Urban Design Review Panel Report

500 Coventry Road, Ottawa

December 12, 2025

**RE: Urban Design Review Panel Report
Site Plan Control Application
500 Coventry Road, Ottawa**

1 ROOF OF MPH WHOLE SITE
1 : 400

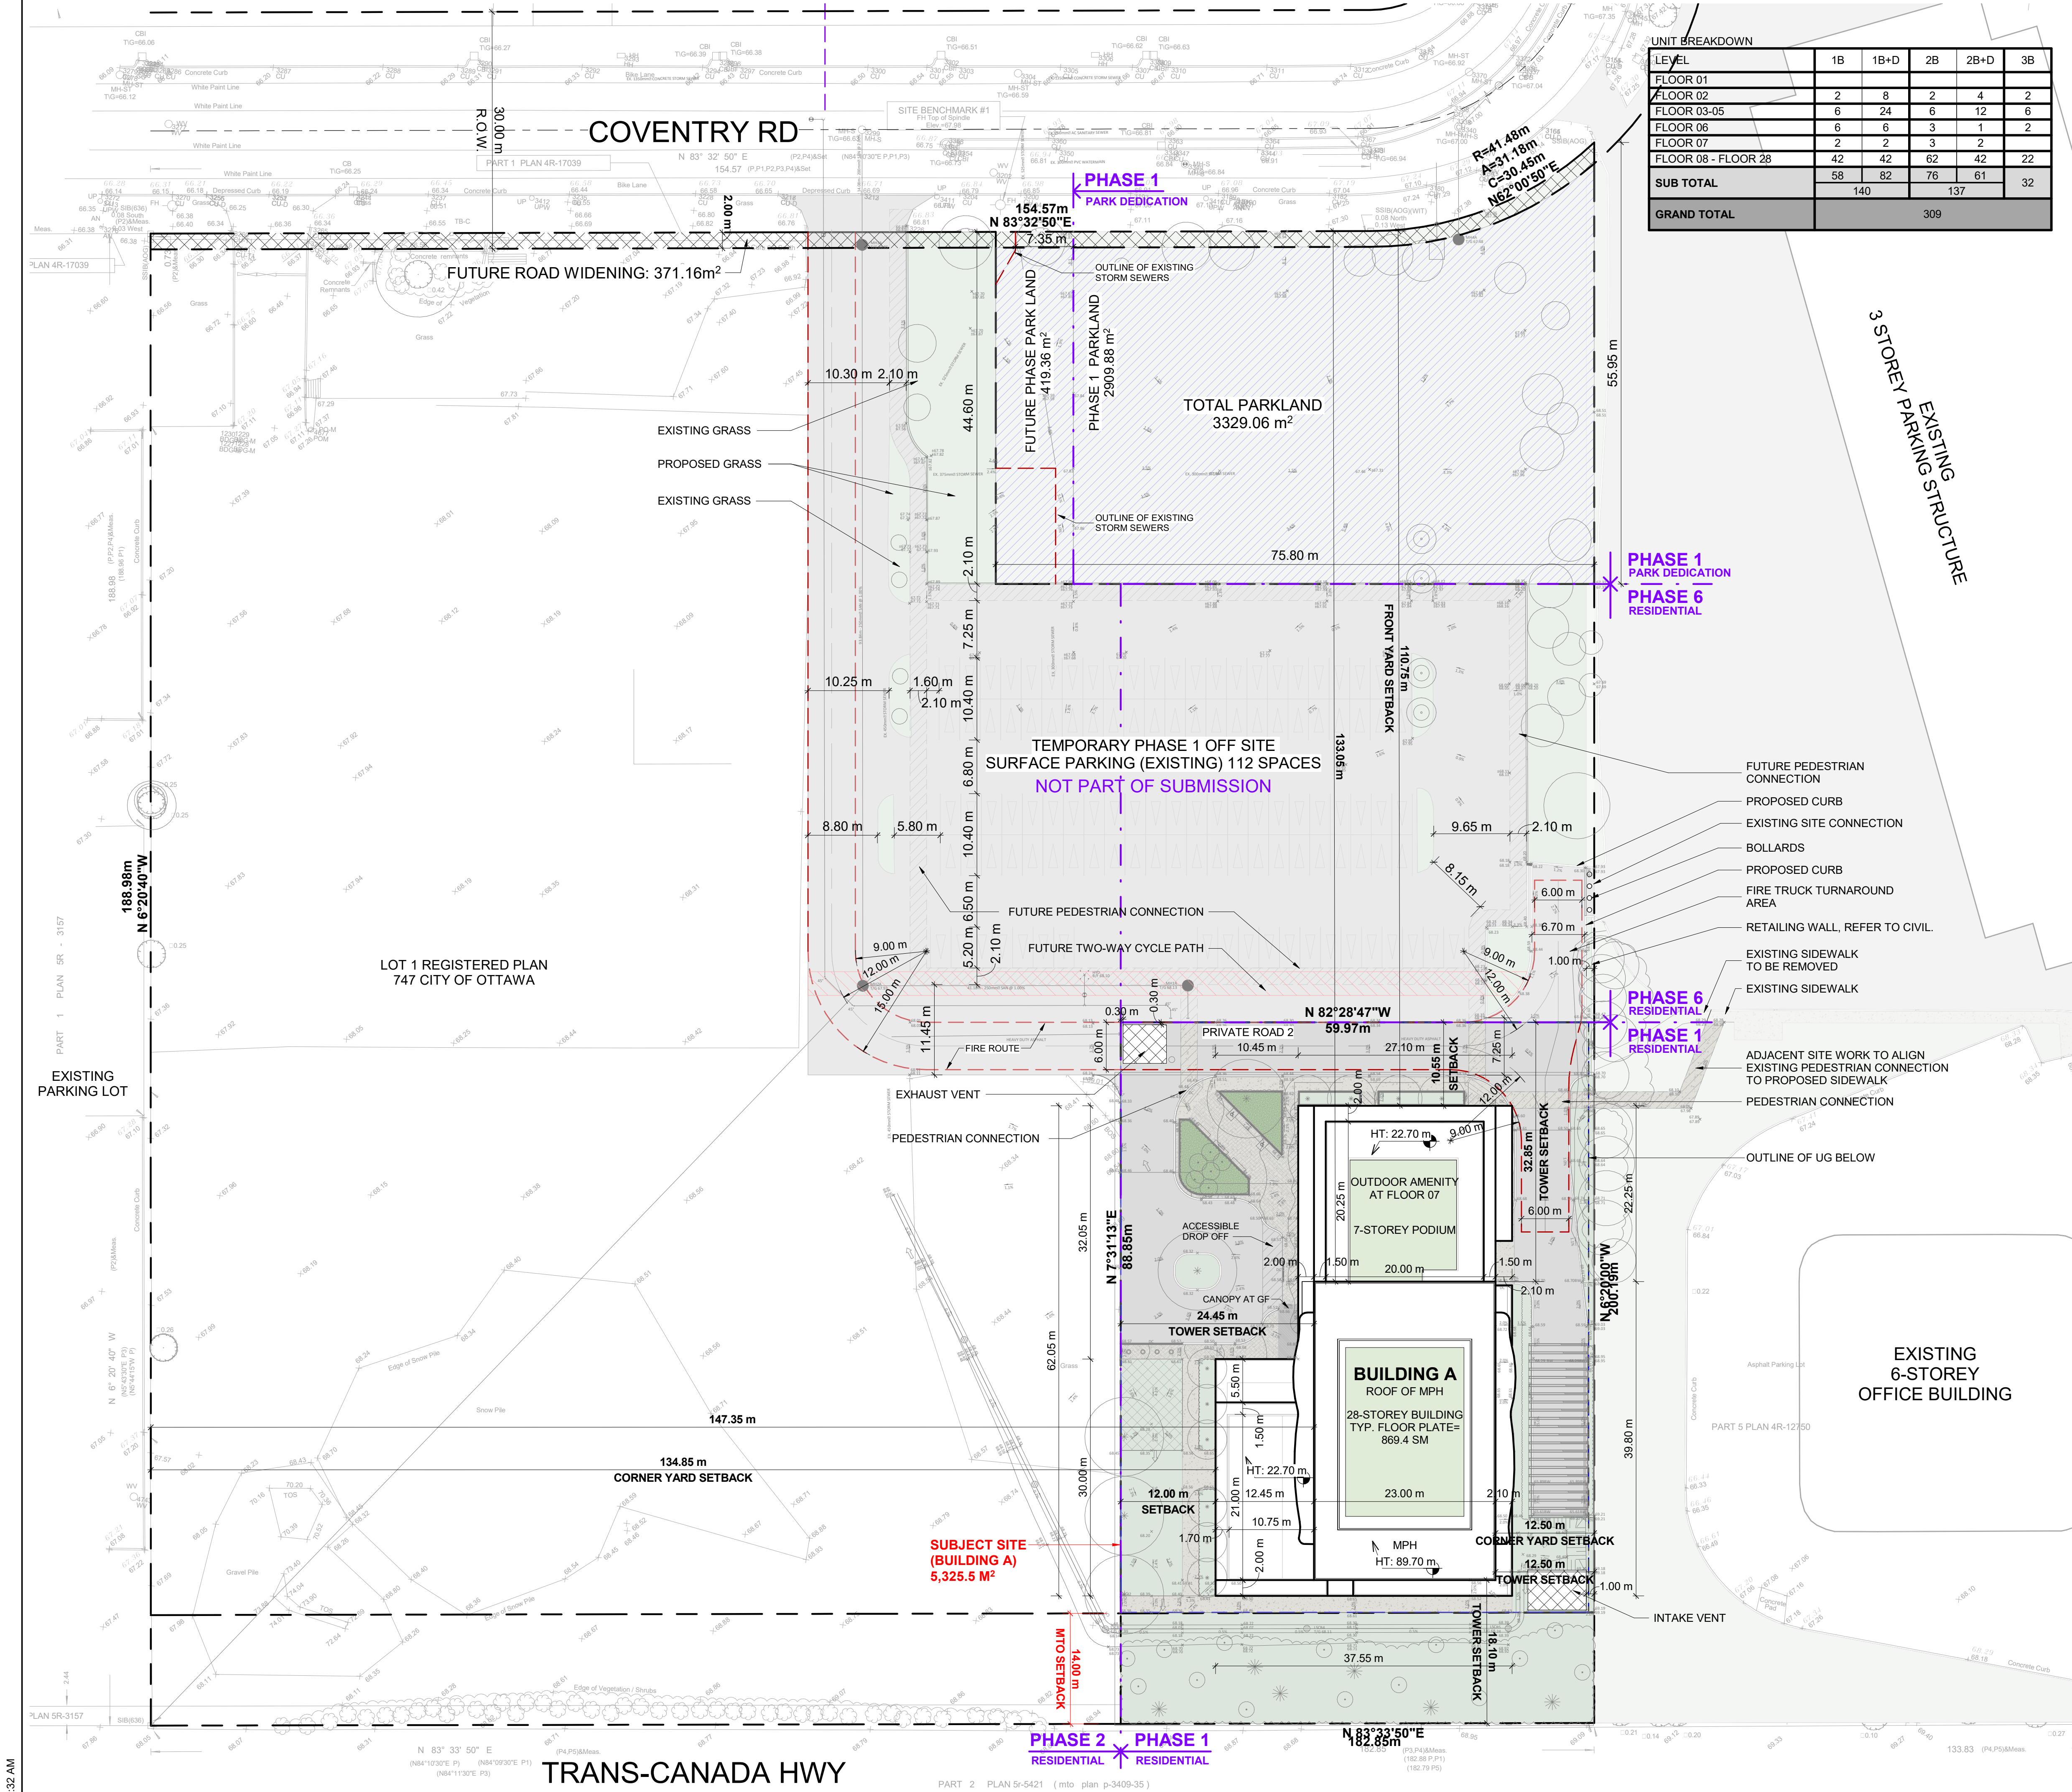
2. The Panel strongly recommends more thought be given to creating a pedestrian-first built environment and layering to the Phase 1 Master Plan presented (p.26), as it currently appears overly vehicle oriented.

3. The Panel recommends further exploring ways in which the vehicle-oriented roads can be evolved into pedestrian-oriented streets, with consideration of how these streets will be activated/animated with pedestrians.

6. The Panel recommends the dedicated parkland be lined with grade-related units to further activate the park space, and that vehicular uses such as loading/drop-offs be relocated away from the park.

7. The Panel recommends further exploring how best to terminate long views with architectural interest. Consider opportunities for communal pavilion spaces and/or sculptural elements to help anchor views and bring people in the community together.

8. The Panel has concerns about the underground parking ramps being exposed and highly recommends tucking the parking ramps within the building envelope.

13. The Panel appreciates that this master planned area, and Coventry Road more generally, presents a challenging landscape to establish a new high-rise community.
 - The Panel has strong concerns with how this master planned community will establish a robust and pedestrian-first public realm environment, given its existing light industrial and car-oriented commercial character.

15. The Panel recommends adding more linkages through the site to the dedicated parkland on the corner.
 - For example, connect pedestrian green space between Building F and Building D to create amenity spaces for pedestrians instead of multiple loading and drop-off areas.
 - Consider connecting the communal amenity to other pedestrian areas, rather than the existing 'island' effect presented by surrounding vehicular circulation.
 - The Panel recommends dialing back the vehicular components of the master plan in return for a more pedestrian-first public realm environment. Pedestrians ought to be the highest order of mobility in the master plan.

16. The Panel recommends exploring designs for a pedestrian pathway that wraps around the site on all sides and connects the amenity spaces to the outdoors.

23. The Panel appreciates the long axial views provided in the Master Plan and recommends further exploring the role of long views into and through the Master Planned site.

Response: Master plan design has been revised to be more pedestrian oriented with less paved road. Refer to sheet SPA005A.

Response: Master plan design has been revised to be more pedestrian oriented with less paved road. Refer to sheet SPA005A.

Response: Townhouses at grade have been provided and loading has been relocated. Refer to sheet SPA005A.

Response: Communal amenity areas have been proposed at the terminal of each long views, with the potential to add landscape and public features. Refer to sheet SPA005A.

Response: Majority of ramps have been internalized. The addition of a parking ramp structure has been designed to partially cover the ramp, tying it into the design of the building. Refer to sheet SPA005A.

Response: Master plan design has been revised to be more pedestrian oriented with less paved road. Refer to sheet SPA005A.

Response: Pedestrian green space provided between building D and F, amenity areas are more interconnected, and more focus on the pedestrian was introduced to the updated master plan design. Refer to sheet SPA005A.

Response: Pedestrian pathways provided on the interior of the site but not the perimeter to bring the focus back on the community inside the master plan. Refer to sheet SPA005A.

Response: Communal amenity areas have been proposed at the terminal of each long views, with the potential to add landscape and public features. Refer to sheet SPA005A.
